A46 Newark Bypass

Scheme Number: TR010065

Statement of Common Ground with Nottinghamshire County Council

**Statement of Common Ground with
Nottinghamshire County Council**

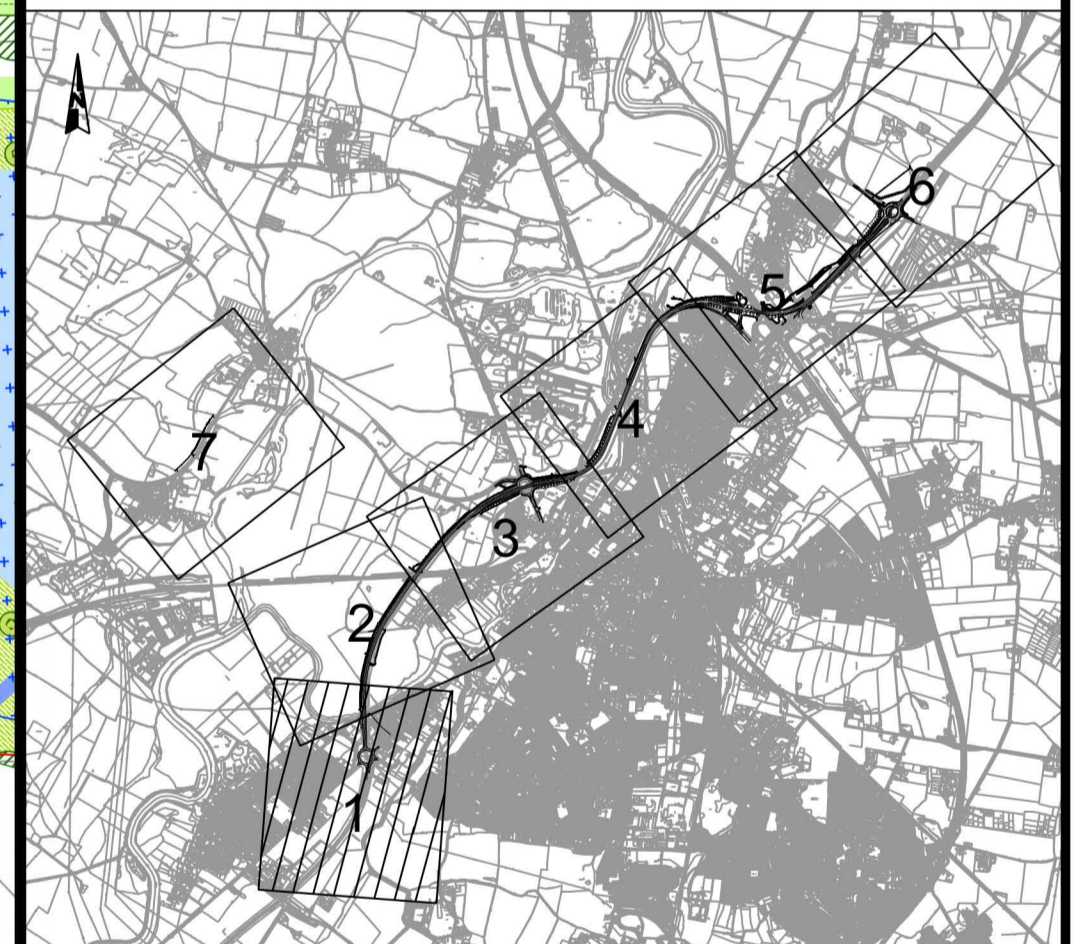
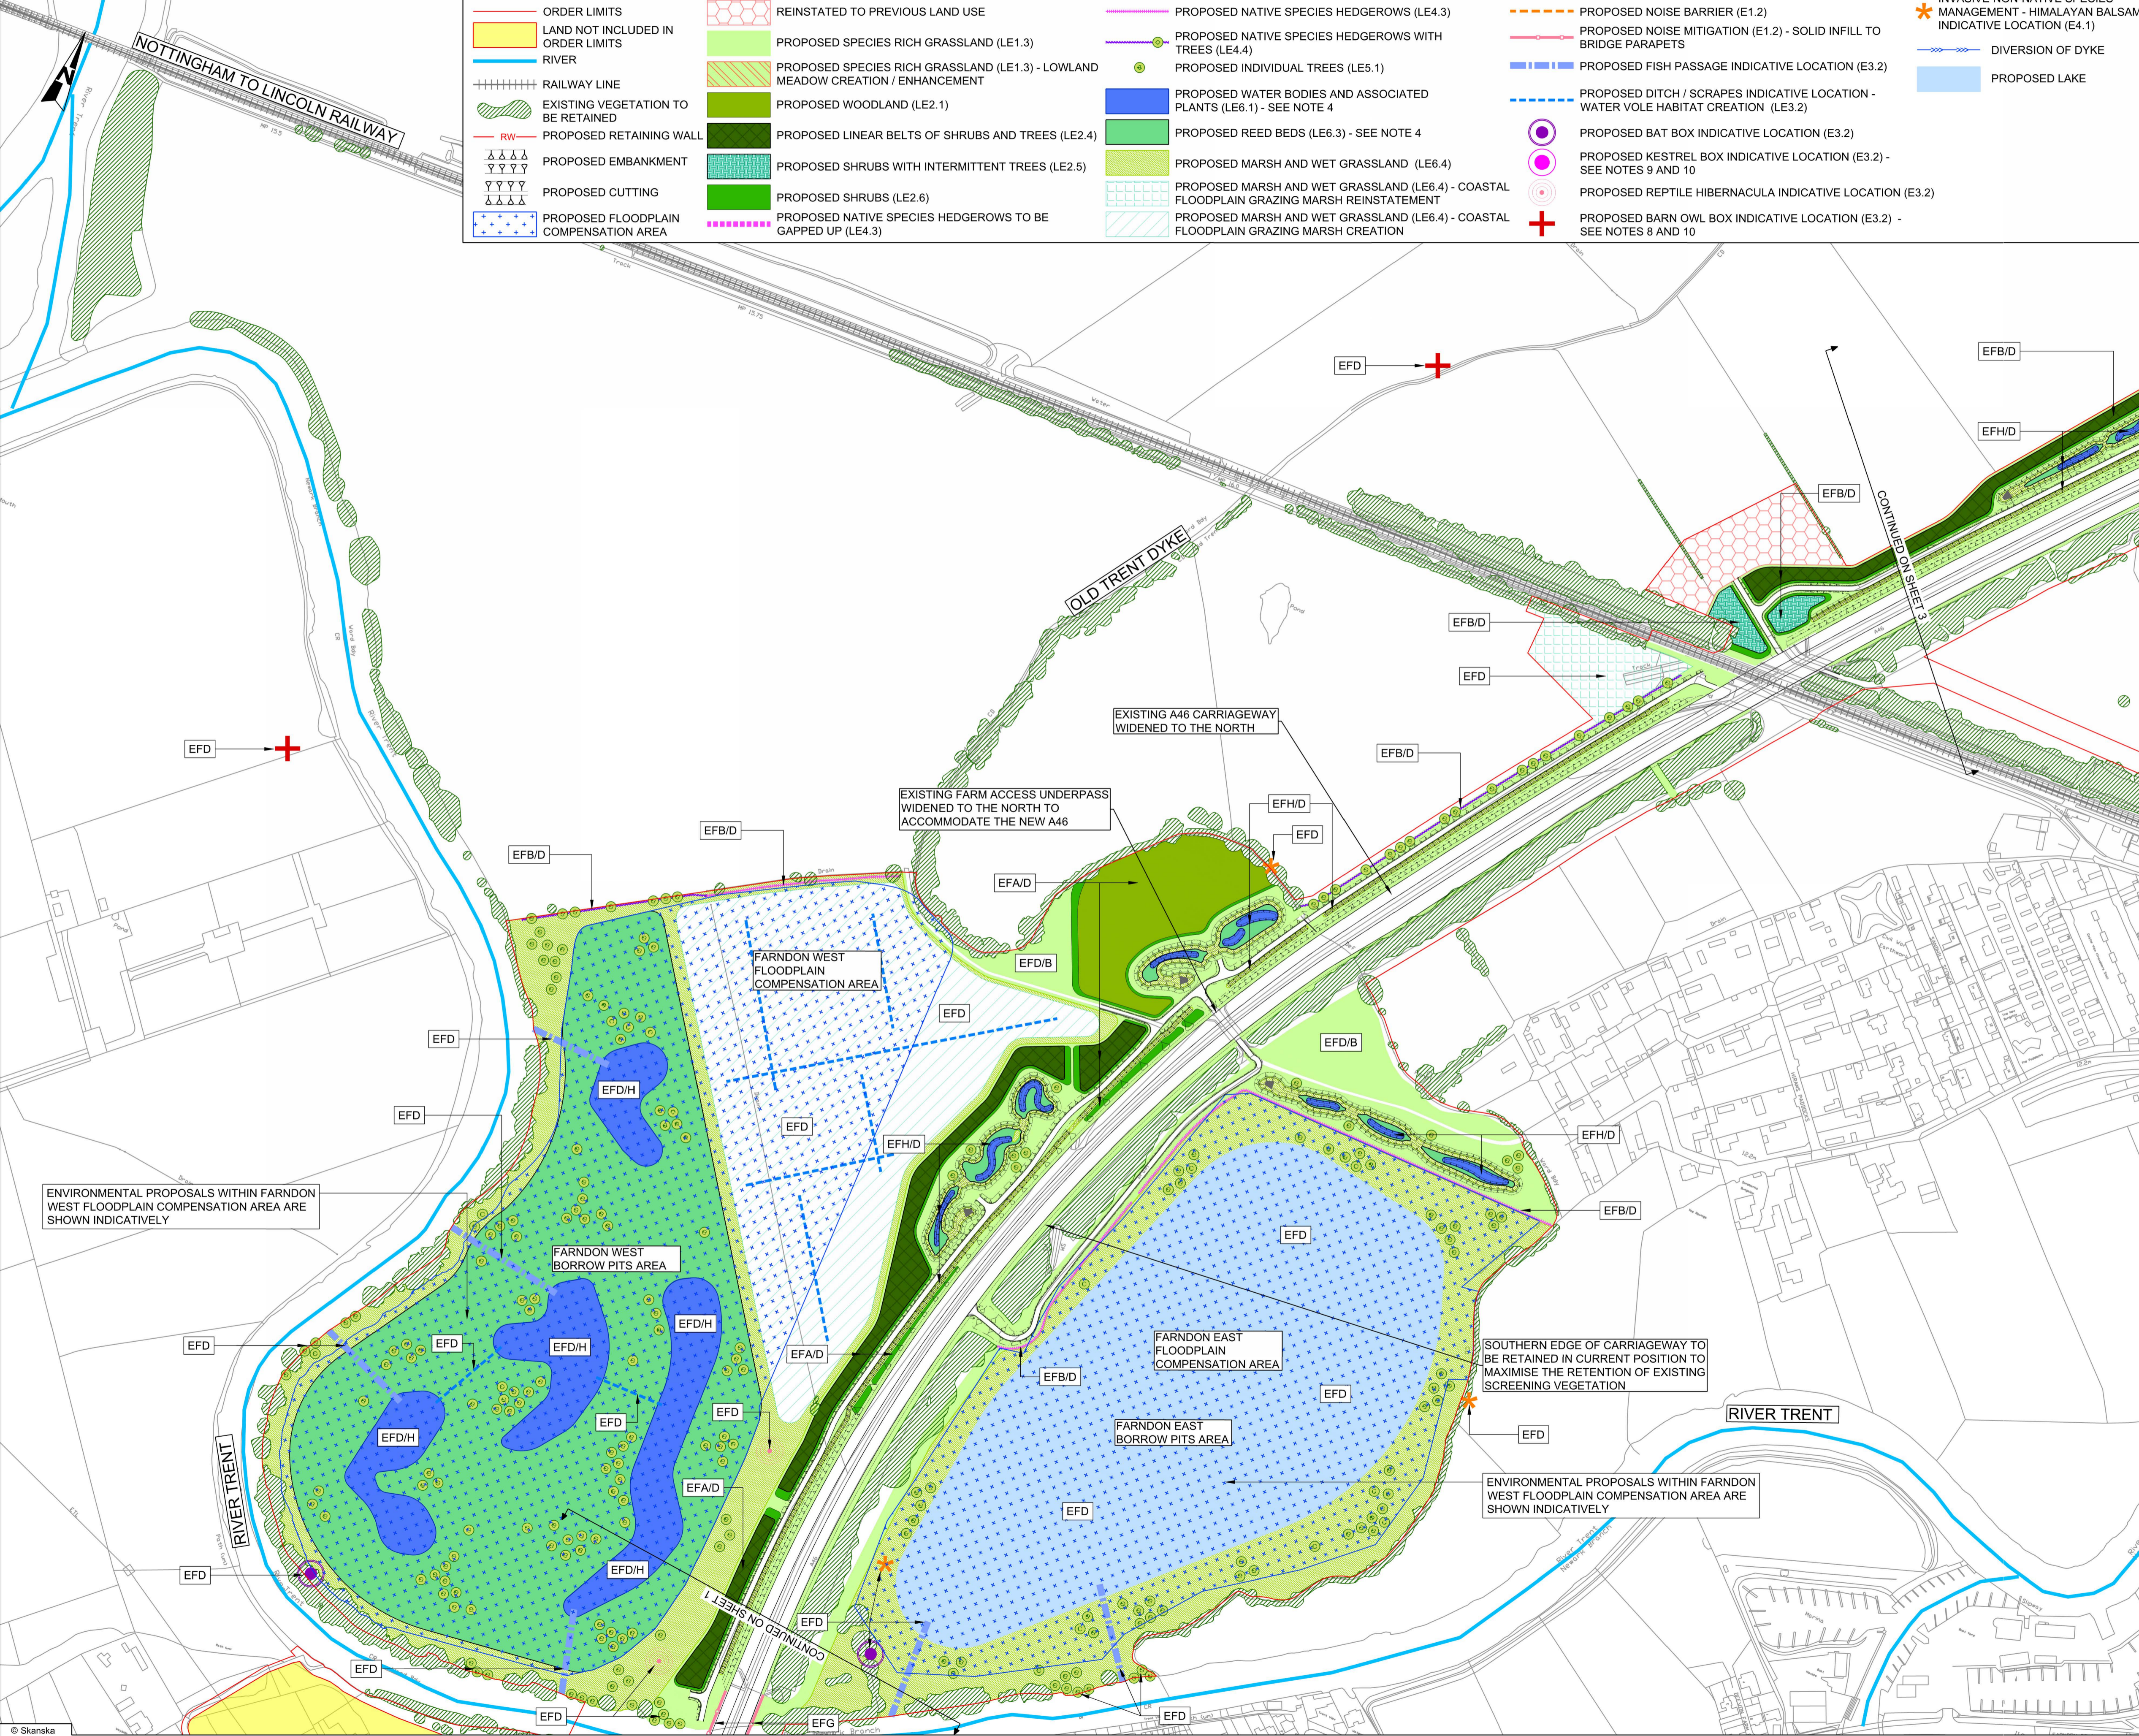
5.	PRoW		Farndon A46 roundabout The plans indicate that the Farndon Underpass will remain open throughout the works which is good. As you are aware the land adjacent to Crees Lane is currently used by members of the public as a walking route, we are also aware that National Highways are planning to use this as a compound. We would support the opportunity to create a public footpath at this location to link the underpass with Footpath No.5 and Bridleway No.2. Farndon A46 roundabout - the land which is set out for the works compound adjacent to Crees Lane has a number of unrecorded desire lines through it. It would be advantageous to see these formally recorded and set out following completion of the Scheme.	Following feedback received as part of the statutory consultation, the temporary diversion of bridleway BW2 was changed, and an alternative route was presented as part of the targeted consultation on the Scheme between 14 March and 16 April 2023. Following further feedback received as part of the targeted consultation the temporary diversion of the bridleway will be only for use by equestrians. Pedestrians and cyclists will utilise the existing footpath FP5 from the River Trent to gain access to the route adjacent to Crees Lane shown within the Order Limits. The unrecorded desire lines are on a piece of land that has been identified for temporary use as part of Scheme, any activity to formally record these desire lines as Public Rights of Way would need to be undertaken by stakeholders, including NCC, outside of the Scheme.	Agreed	04/11/2024
